SICEEP, The Haymarket – Response to City of Sydney Council

Recommendation 39: The shared path on the western edge should be removed and a bi-directional cycleway should be installed on Darling Drive. An extension of the same public domain treatment as is evident towards the southern half of the building – i.e. the street tree planting and understorey landscaping – should be extended north to meet the roundabout at the Pier Street intersection.	Recommendation 38 provides commentary on the feasibility of a bi-directional cycleway on Darling Drive. The proposed shared pathway is consistent with the requirements of Austroads Guide to Road Design, Part 6A: Pedestrian and Cyclist Paths. The proposed shared way recognises the mingling of pedestrians and cyclists through the desire lines from the student accommodation building to the Exhibition Light Rail stop to the north and across Darling Drive at the pedestrian crossing connecting through to Dickson's Lane.

PROJECT NUMBER	DRAWING NUMBER	REV
005198	L211	F

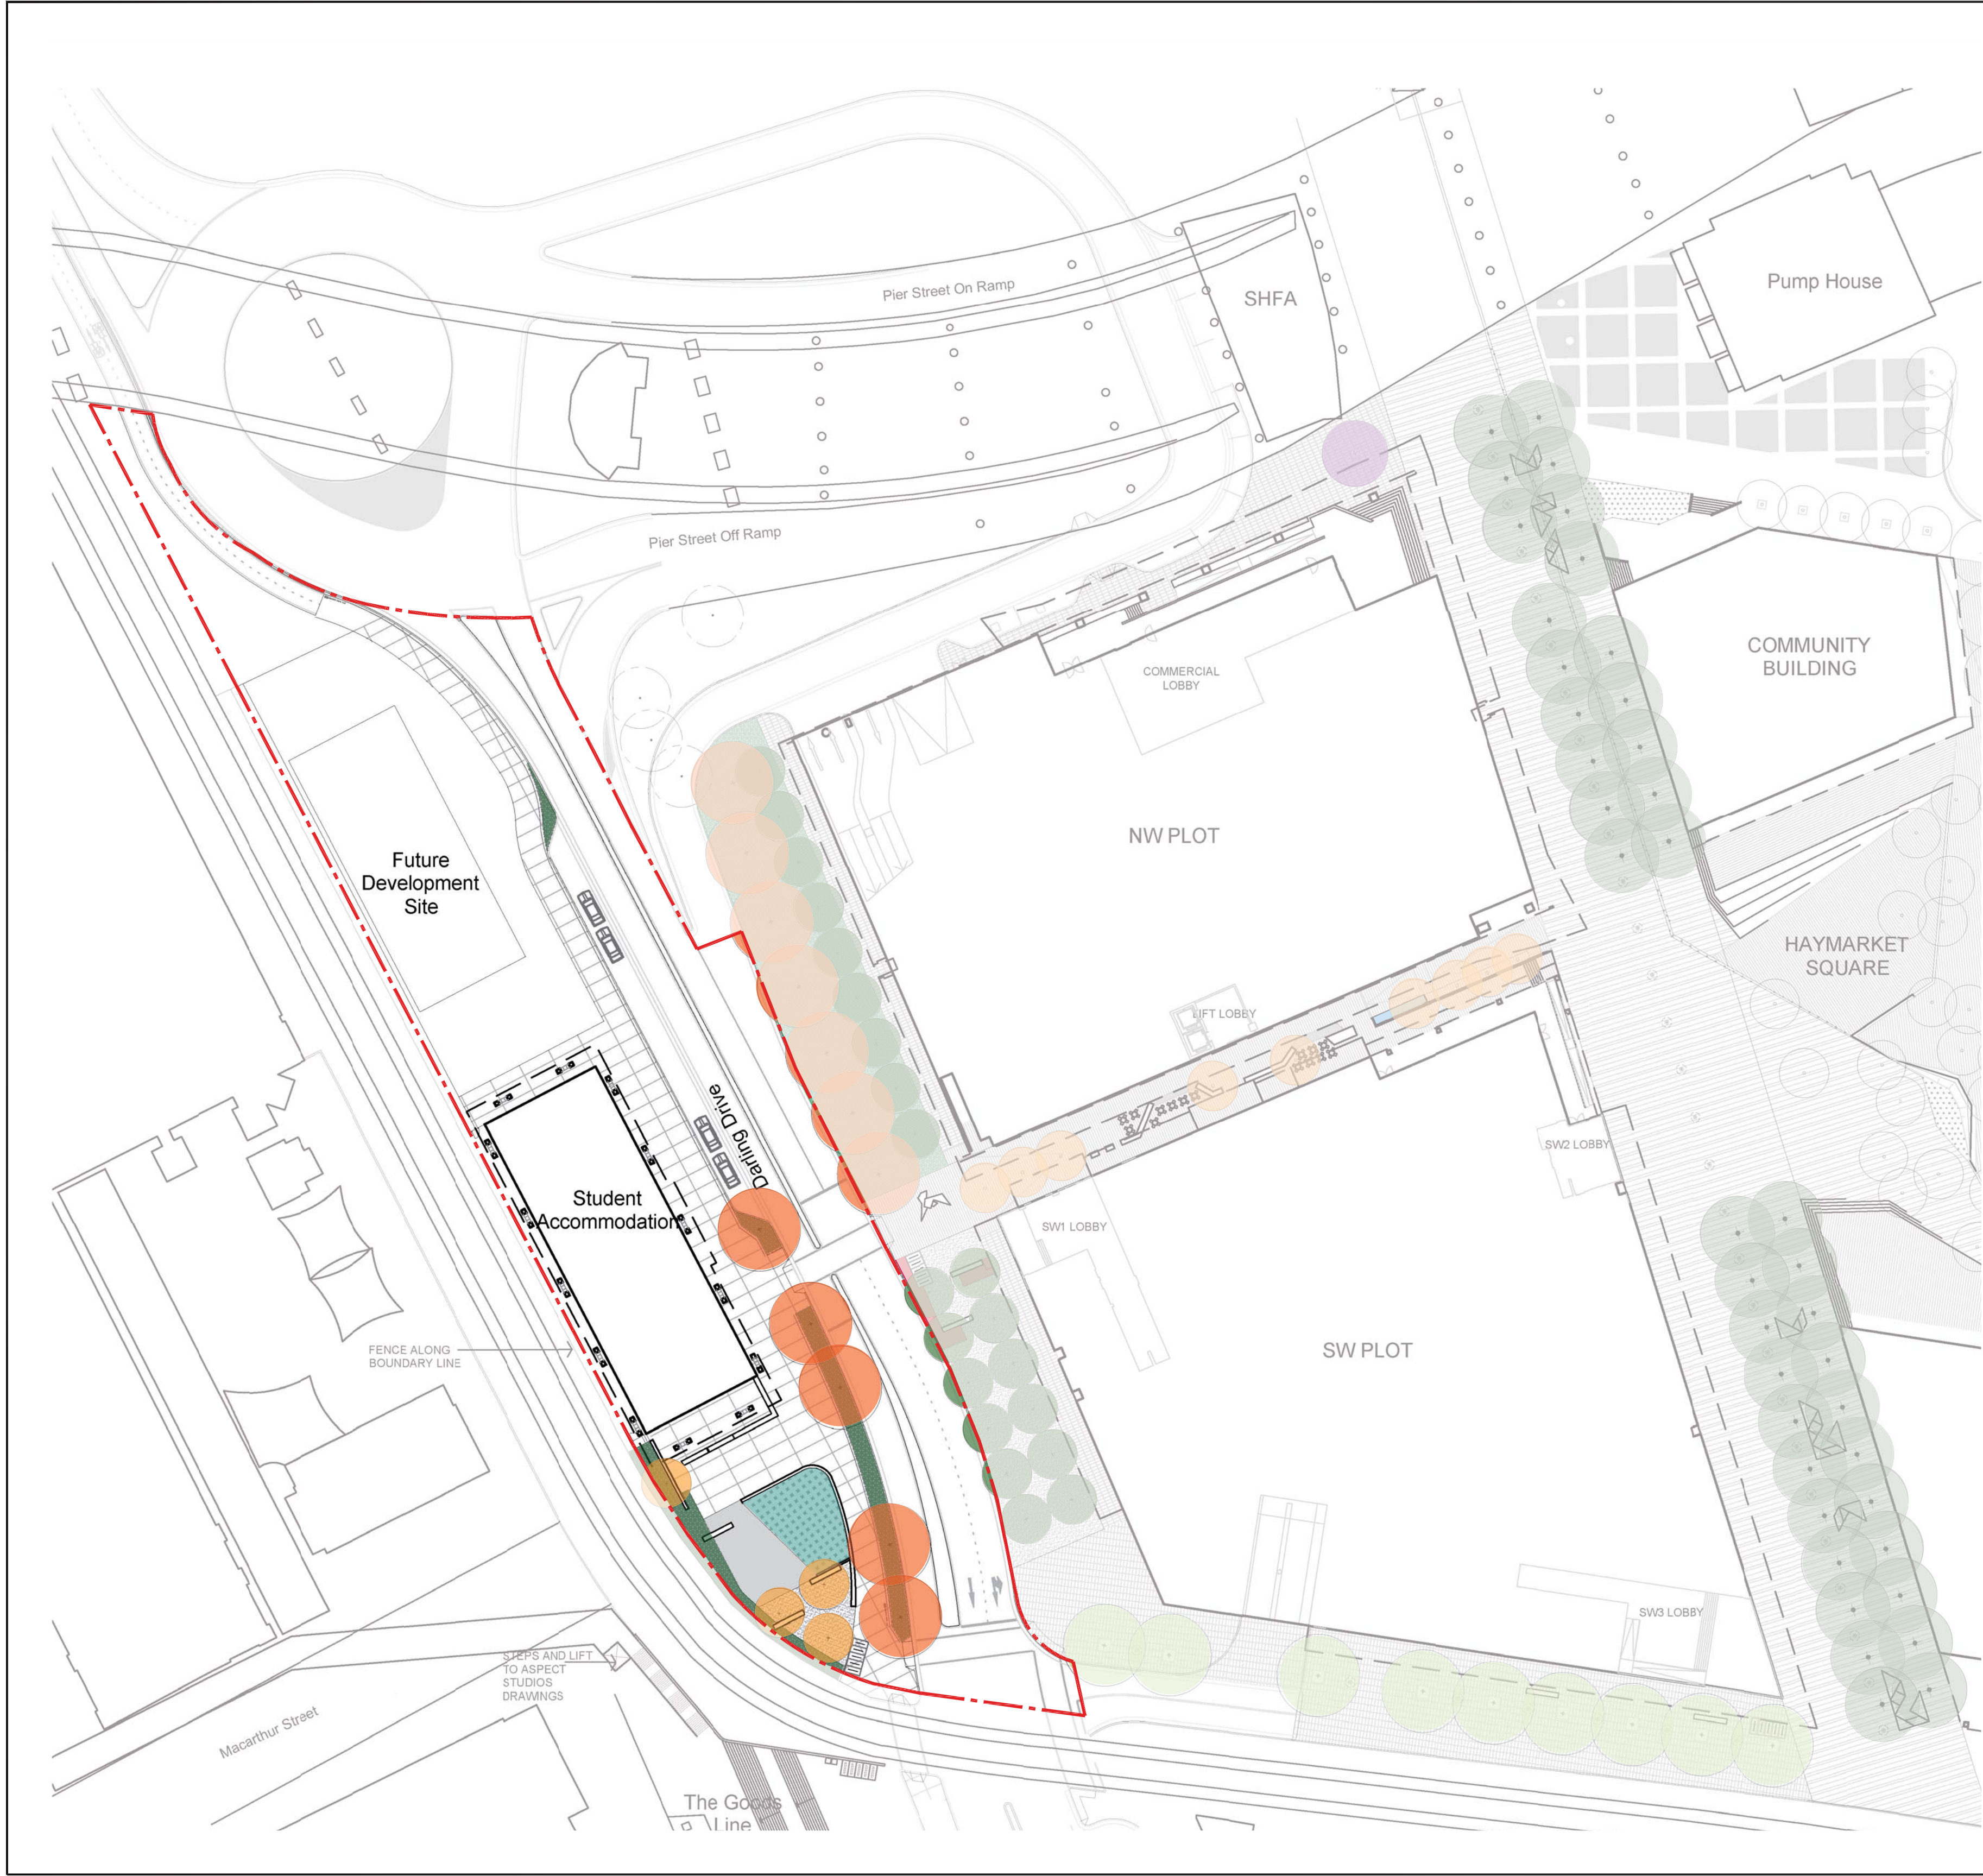
Recommendation 48: The planting of <i>Flindersia australis</i> to Darling Drive is not supported. <i>Lophostemon confertus</i> is preferred. The planting of <i>Acer 'Sango Kaku'</i> is not supported. <i>Backhousia citriodora</i>, <i>Fraxinus griffithii</i> or <i>Lagerstroemia indica</i> is preferred.	Darling Drive planting Upon further detailed review and assessment by the project soil scientist and advising horticulturalist, and feedback from the project civil engineering consultants on the available root space for the Darling Drive street trees, <i>Lophostemon confertus</i> is proposed to the entire length of Darling Drive. Tree stock has been confirmed as available at 800L size. <i>Lophostemon</i> as a species has been accepted as the most appropriate species choice based on: - Its tall, upright habit which will not impede on vehicular site lines; - Mature height of 15-20m will provide an appropriate scale to the built form; - Strong pollution (air and stormwater) tolerance; - Resistance to disease and pests; - Ease of establishment; - Low maintenance; - Proven longevity in urban environments; - Dense evergreen canopy; - Non-invasive root system; and - Consistency along the length of Darling Drive from Hay Street in the south, through to the northern extents of the PPP boundary. In order to ensure the species performance within an urban environment several conditions are to be allowed for. These include appropriate subsoil drainage, site specific soil medium and a non-compacted root surface zone planted with groundcovers to increase air and water exchange.

Issue	Response
	The City of Sydney's alternate species nomination, <i>Eucalyptus robusta</i>, is proposed as one of the dominant species for the length of the Boulevard. Given the prevalence of this species within the master plan already, the proposed planting strategy has been adopted as it will deliver a different species along Darling Drive to help define the space and create a visual point of difference. Substitution of planting for Acer 'Sensation' The design for this key public space node of the site, recognises the need for a public area immediate to the student foyer to function effectively as an extension of the internal building space and to ensure a consistent environment for the students. Due to the space located at an intersection point between light rail, road, cycle and pedestrian desire lines, a small cluster of deciduous trees that offered seasonal change and provided a 'marker', was deemed suitable. After further consultation with both horticultural and arborist experts, the planting of Acer 'Sango Kaku' has been substituted for Acer 'Sensation'. The Acer 'Sensation', has been specifically selected and is considered superior for the below reasons: - Form and vase shaped habit (mature height of 7m and width of 3.5m), allowing seating for students under; - Tolerance of summer sun exposure; - The variety is sterile; - Foliage achieves strong seasonal change of bronze-burgundy growing tips the turn mid green in summer in a Sydney environment and - The bark and new stems create a striking winter colour effect when the tree is defoliated. City of Sydney recommendations are not deemed appropriate for this design intent for the following reasons: - <i>Backhousia</i> is evergreen and will not provide the seasonal change and the provision of sun in winter; - <i>Fraxinus</i> is deemed to have insufficient seasonal change and; - <i>Lagerstroemia</i> is a tree species already proposed as a significant feature tree within the wider public realm and therefore not considered suitable for this space as it has the potential to dilute the effect of the plantings to the Chinese Garden forecourt.
